Your Ref:
Our Ref: EN010139
Date: 08 March 2024

Application by RWE Renewables UK Solar and Storage Limited for an Order Granting Development Consent for the Byers Gill Solar project

Advice following issue of decision to accept the application for examination

Sheet 8 of 13

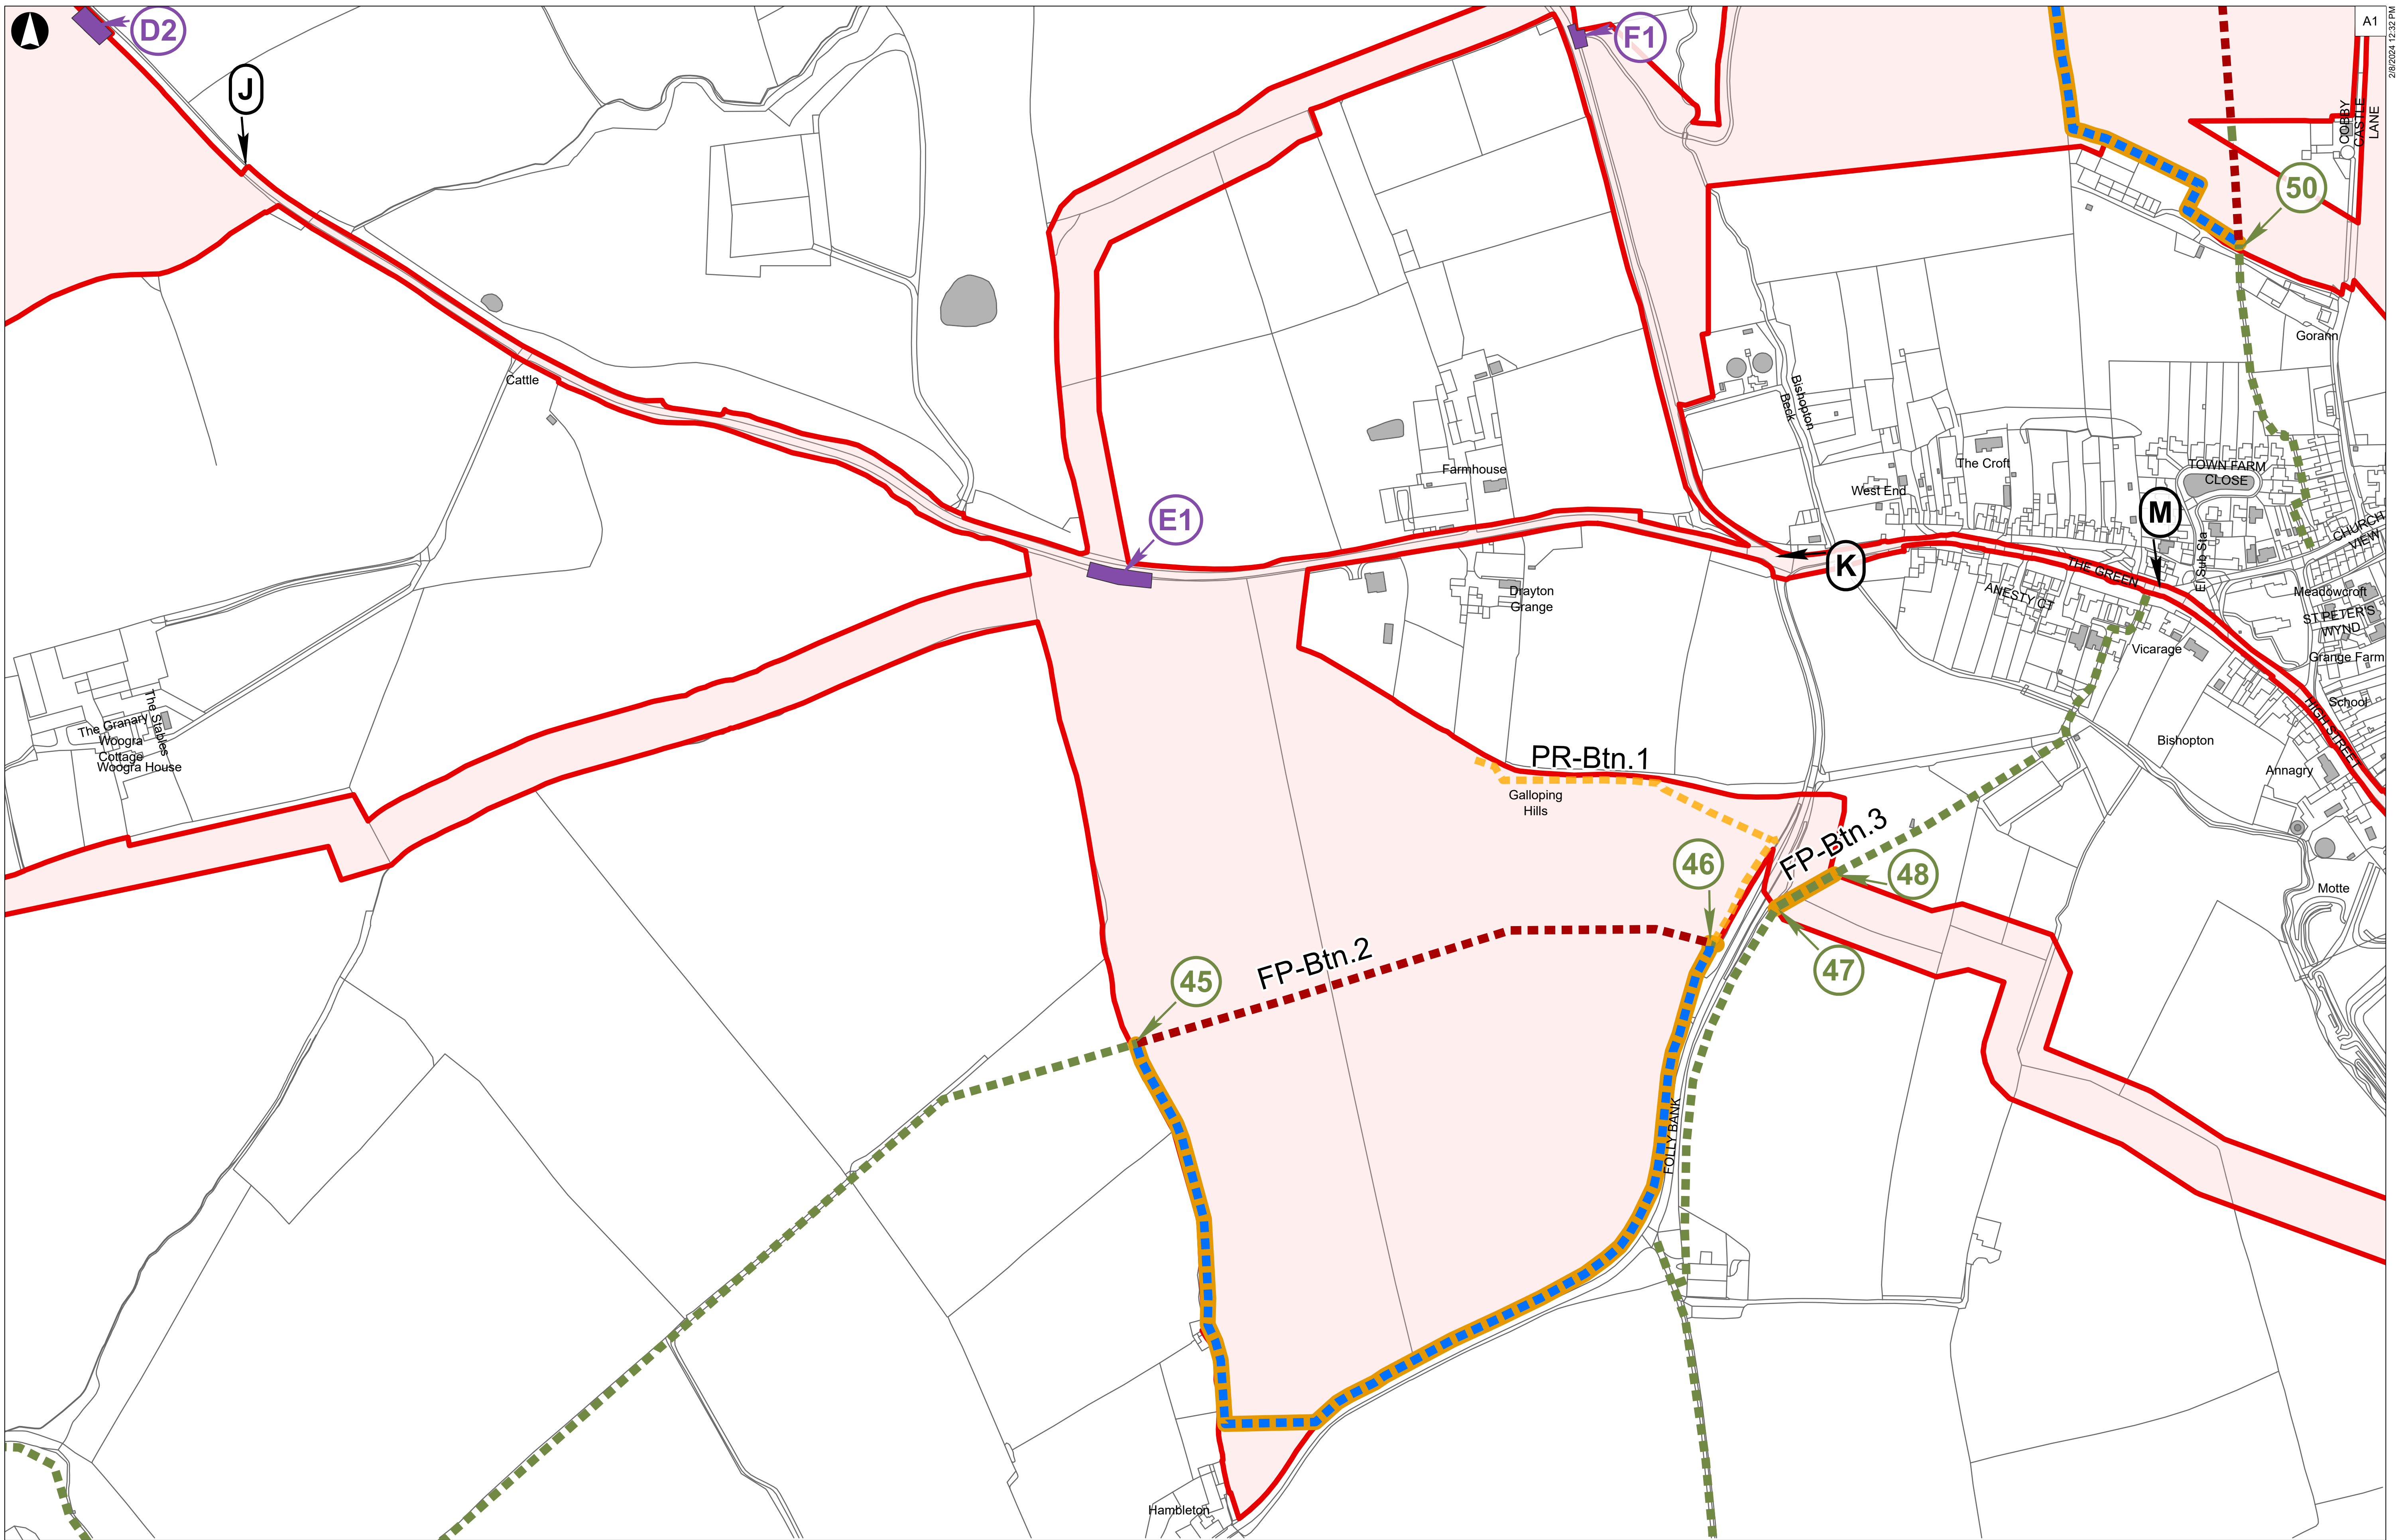
The Inspectorate notes that there appears to be a lack of consistency across the plan sheets regarding street names and additionally there are some named streets which are referenced in the **draft Development Consent Order** that do not appear to have been labelled on the plans, e.g. sheet 7 and 8, Elstob Lane. The Applicant may wish to review the **Street Works, Rights of Way and Access Plans** and amend to ensure consistency and that all roads listed are labelled across all plans.
